**RE: Bosque Plaza – Guardian Storage
Conceptual Grading and Drainage Plan
Stamp Date: 10/20/17
Hydrology File: E12D006E**

Based upon the information provided in your submittal received 10/20/2017, the Conceptual Grading and Drainage Plan **is not** approved for Site Plan for Building Permit. The following comments need to be addressed for approval of the above referenced project:

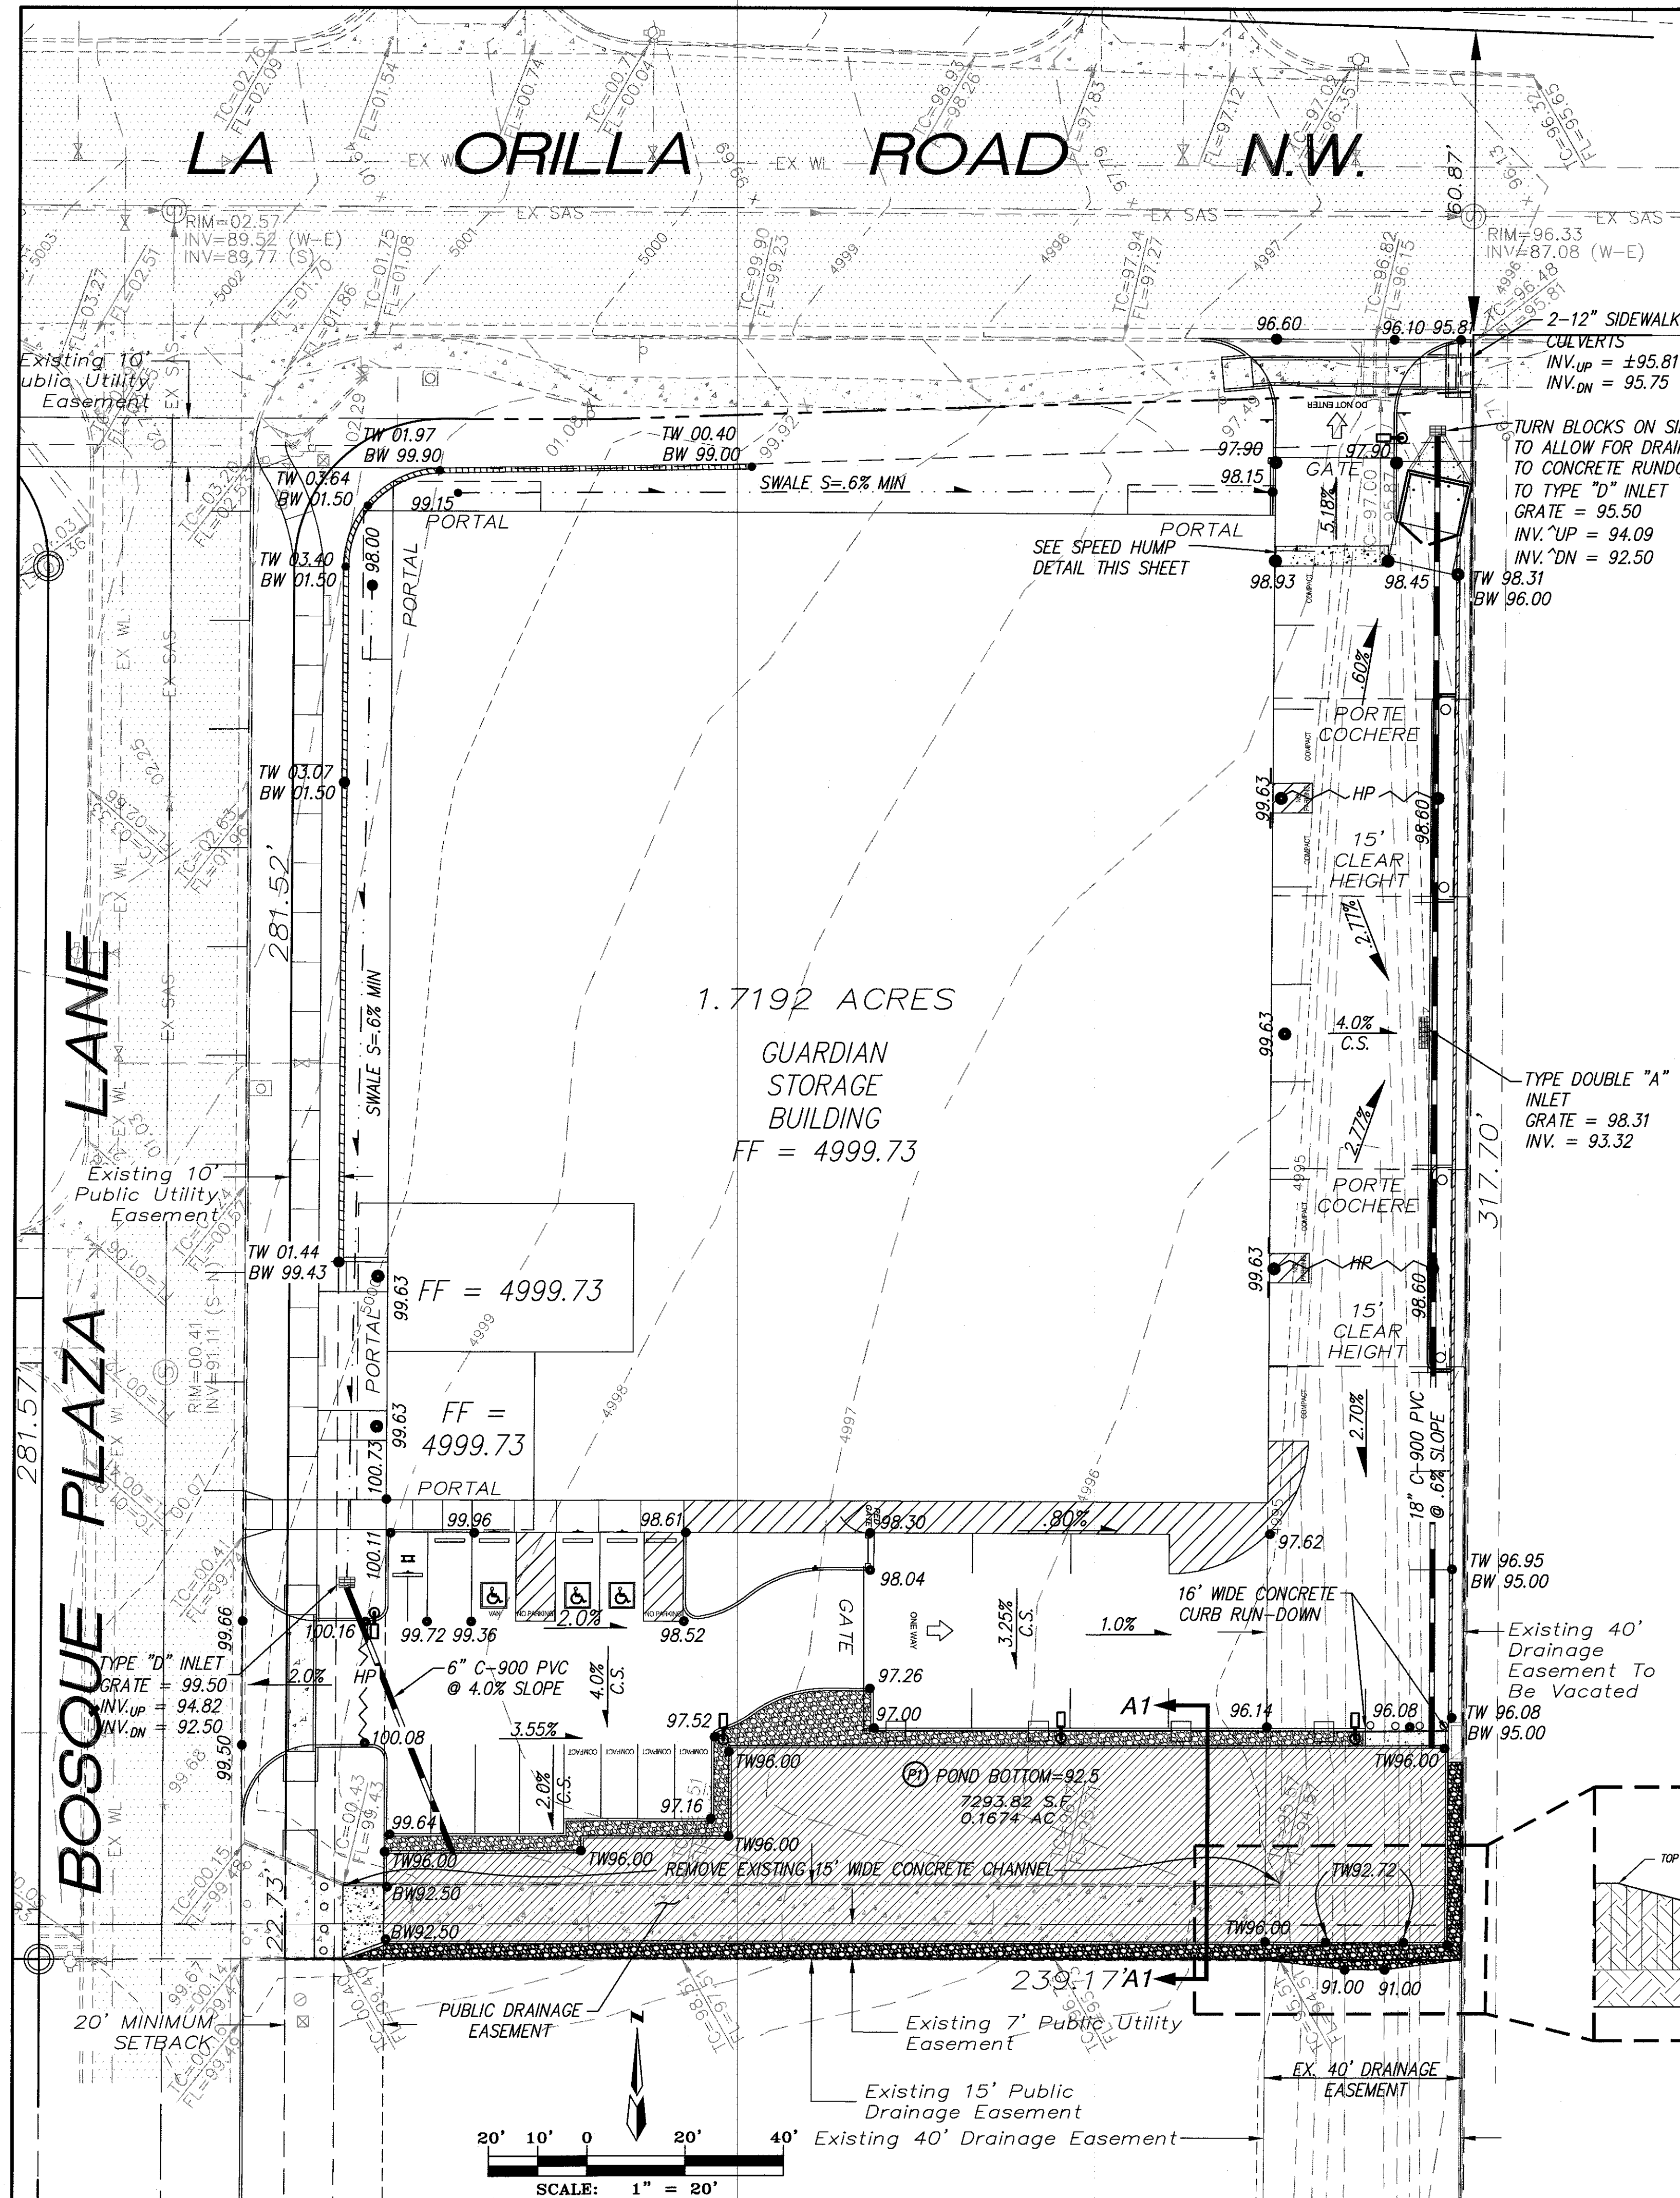
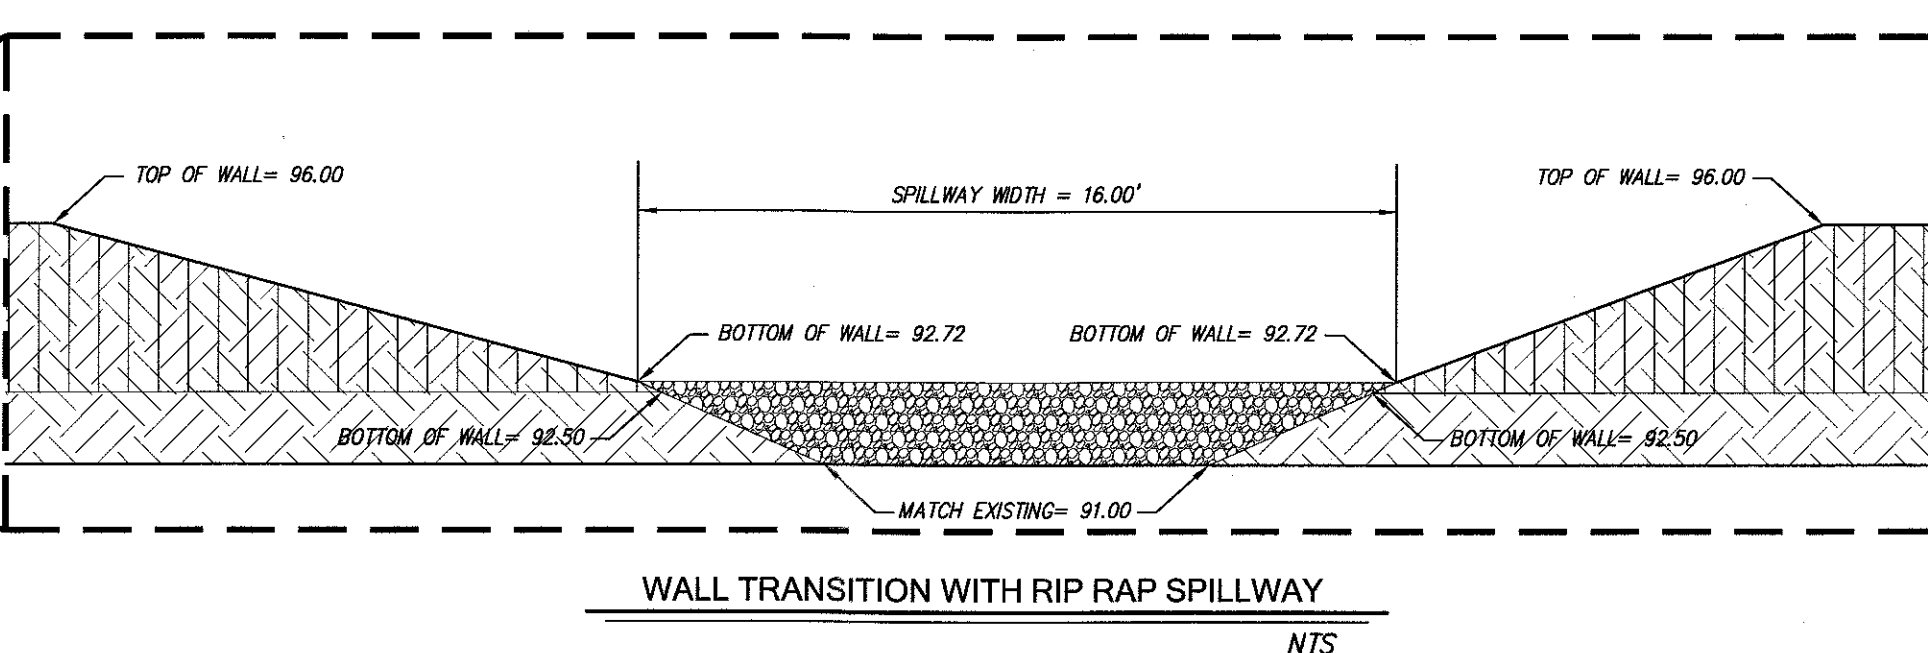
1. See attached aerial with contours from the City's GIS. It appears that the off-site area draining into the existing sidewalk culverts on La Orilla picks up some drainage from Coors as well. Please review and correct drainage area for Basin ID 101.

2. Please show all the Sub-basins within Basin ID 100. A portion of Basin ID 100 drains into the proposed cattle guard inlet.
3. It appears that the cattle guard inlet is about 1.5 feet difference from the west end to the east end. Please provide inlet calculations for this inlet because it appears that half of the inlet will not get any drainage into it. It appears that maybe a Double Type A at the east side of the drive will be better at capturing the runoff from the off-site Basin ID 101. Also if you use this option, please provide the calculations for the inlet.

4. Please label the storm pipe as Public.
5. The public storm sewer pipe and inlet should be included in an Infrastructure List with a recorded SIA. There also needs to be an Agreement and Covenant for the public storm sewer and detention pond. This A&C will need to be recorded prior to Certificate of Occupancy.

6. Please provide calculation for the storm pipe along with the EGL & HGL. It appears that it should be at least 18 inches instead of 12 inches. Also is there a reason that it is C-900 PVC instead of either RCP or HDPE?

7. Please provide the weir calculations for the curb cuts.
8. Please provide a public drainage easement around the proposed detention pond.
9. The existing detention pond was designed to hold a volume of 1.5 ac-ft which it appears about half is along the eastern side of the site and is being filled in. Is there enough volume in the proposed pond to handle this required volume?

10. Please provide an overflow spillway or pipe. If a spillway is provided, would a pump still be needed? It appears that you could just directly outfall into the remainder of the existing detention pond since there is already a pump at the far south end of the pond which discharges at a rate of 1.23 cfs.

11. Please show the 100 year water surface elevation in the ponds cross section.
12. Please change the wording of the pond cross section from "First Flush" to "Detention".

13. Please raise the pond's walls to match the top of curb or the top of the concrete channel. The dirt between these structures will just sluff off into the pond.
